Application number: 2024/91260	
What is the application for?:	Variation of condition 2 (plans and specifications) and 35 (removal of permitted
Address of the site or building:	Land at, Merchant Fields Farm, off Hunsworth Lane, Cleckheaton
Postcode:

status: PLANNING
 project: MERCHANTS FIELD CLECKHEATON
 site: SITE LAYOUT
 drawn: QYRB. date: MAY 2019
 checked: RB. scale: @ A0:1:500
 job no: 122. dsg no: 122-PL-01-V

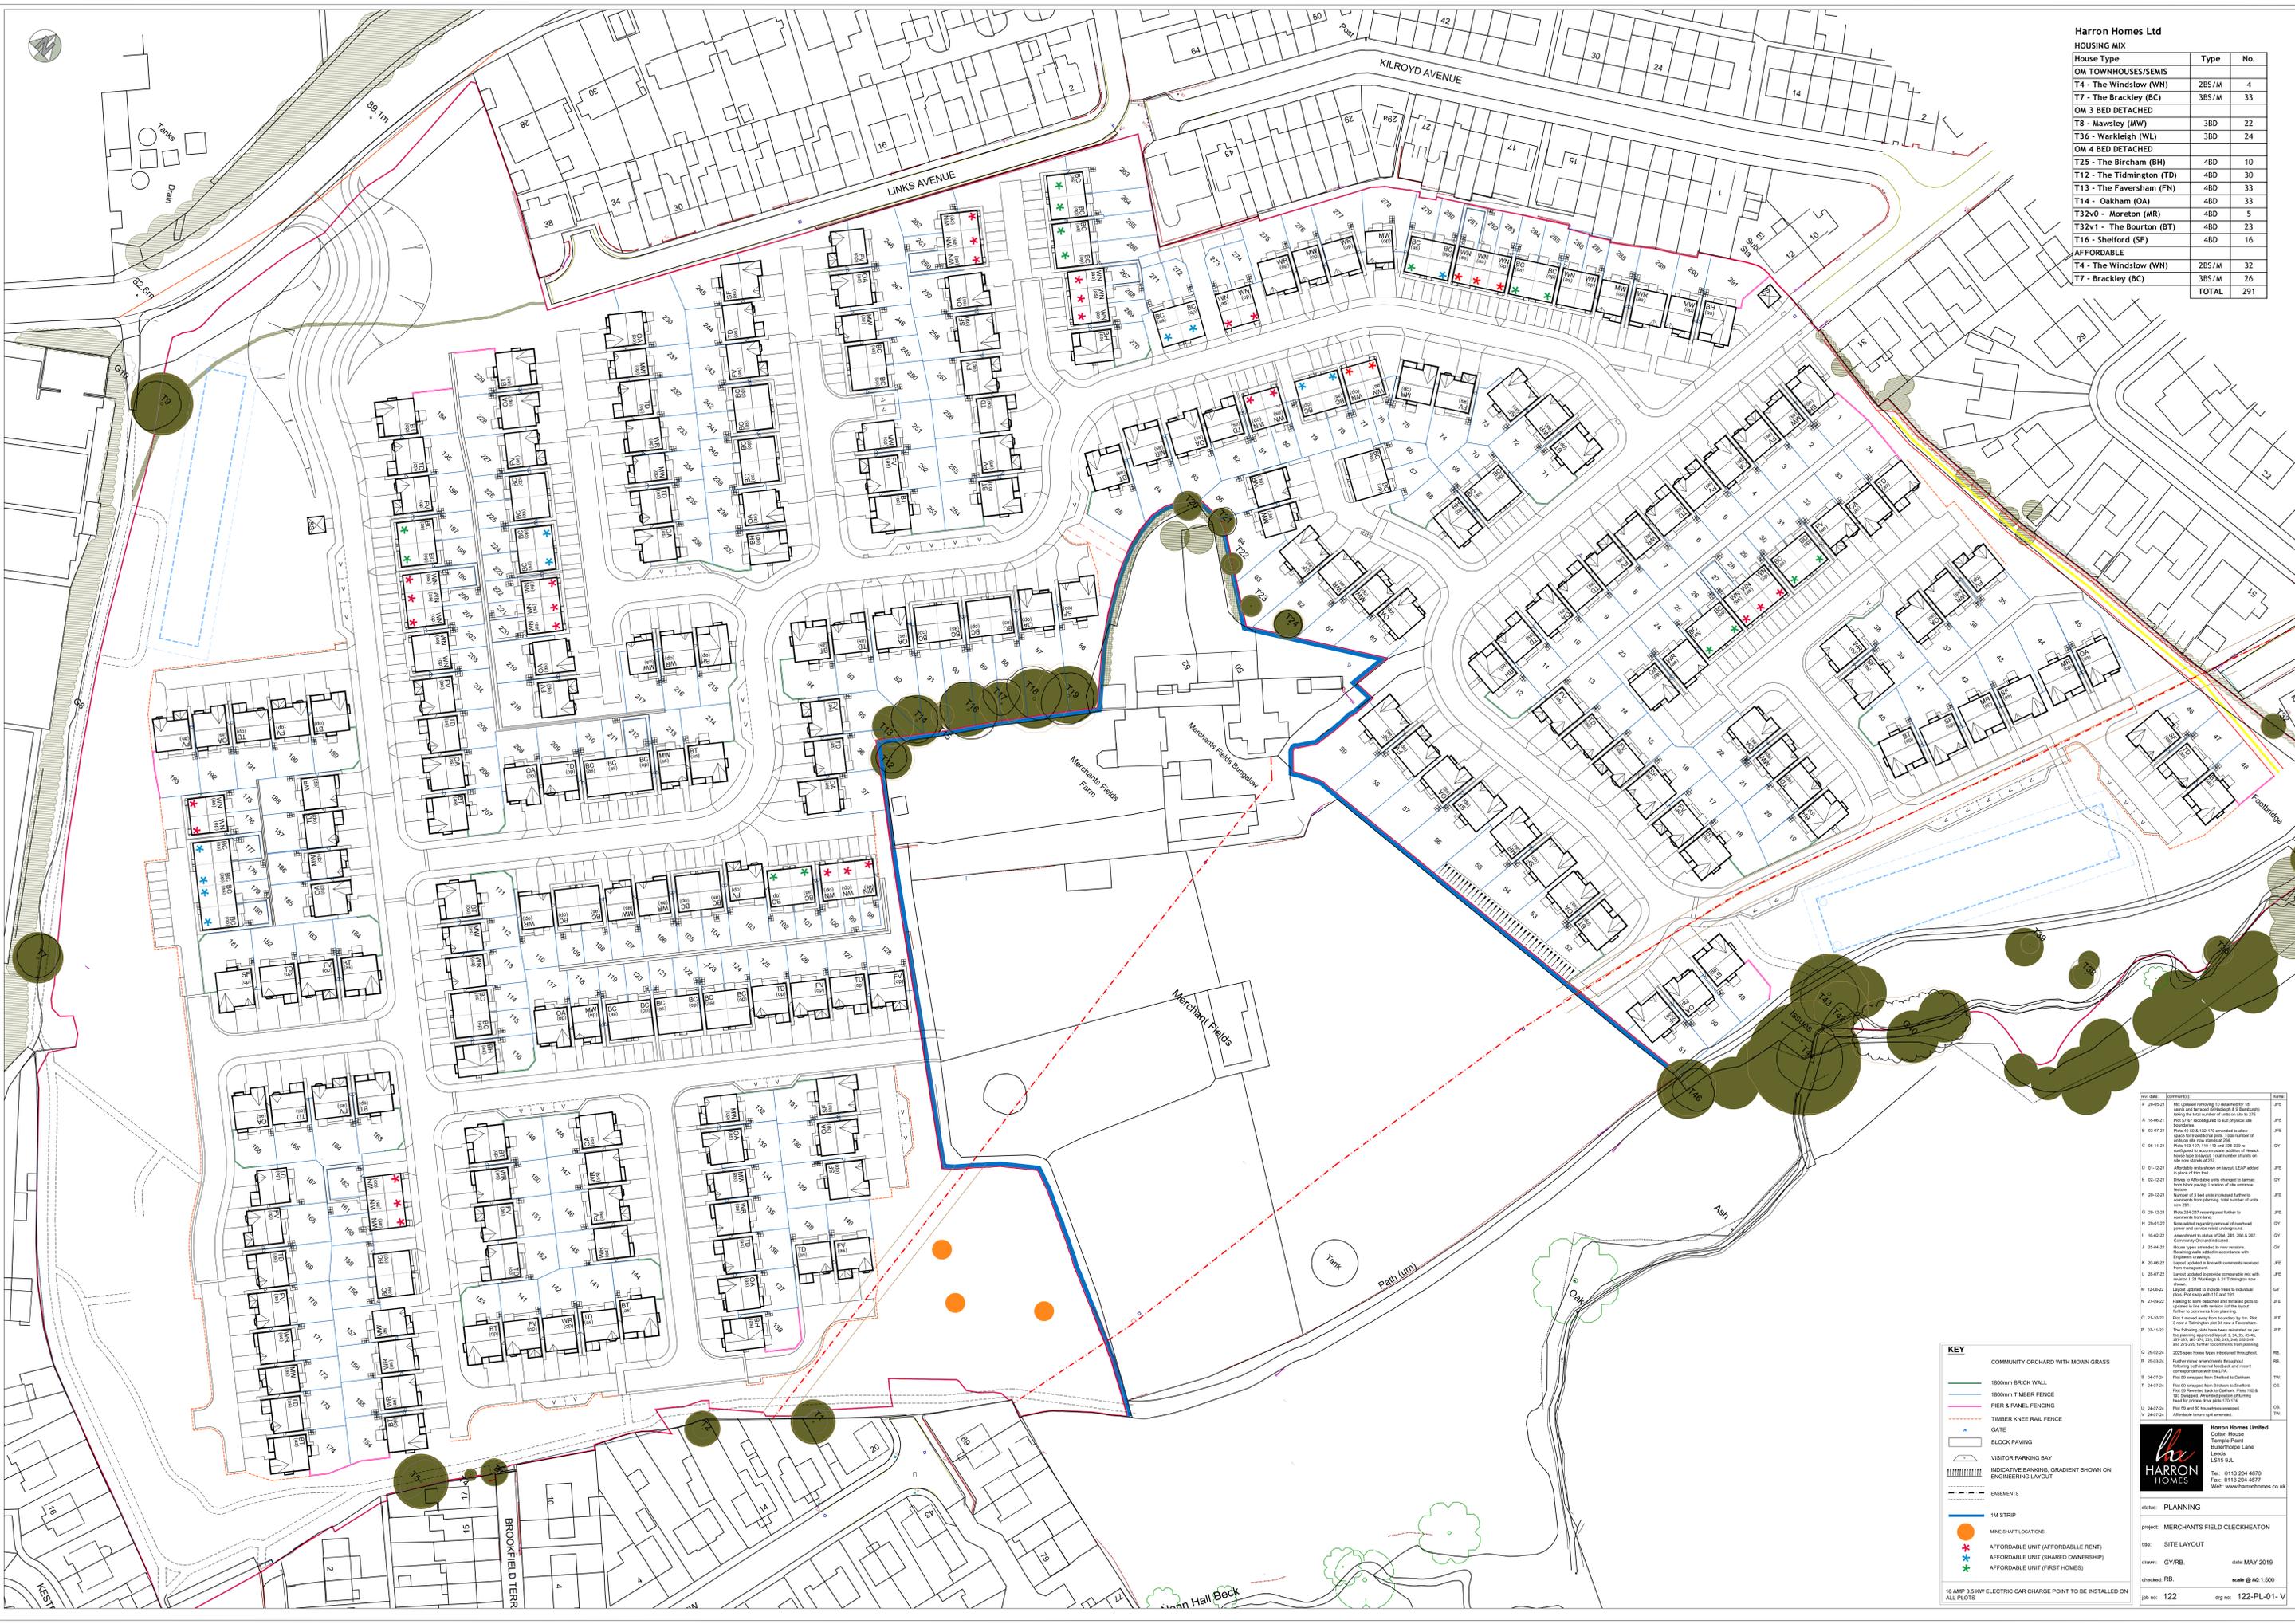
Type of comment: A general comment	
Do you wish your comments to be published on the website anonymously?	<input type="checkbox"/> Yes
On the plans there is a pond that is directly at the back of our fence were is the water coming from and were is it going, fears of antisocial behaviour ,such as drugs and off road bikes on large area in the middle, will large work vehicles be passing 89 brookfield view
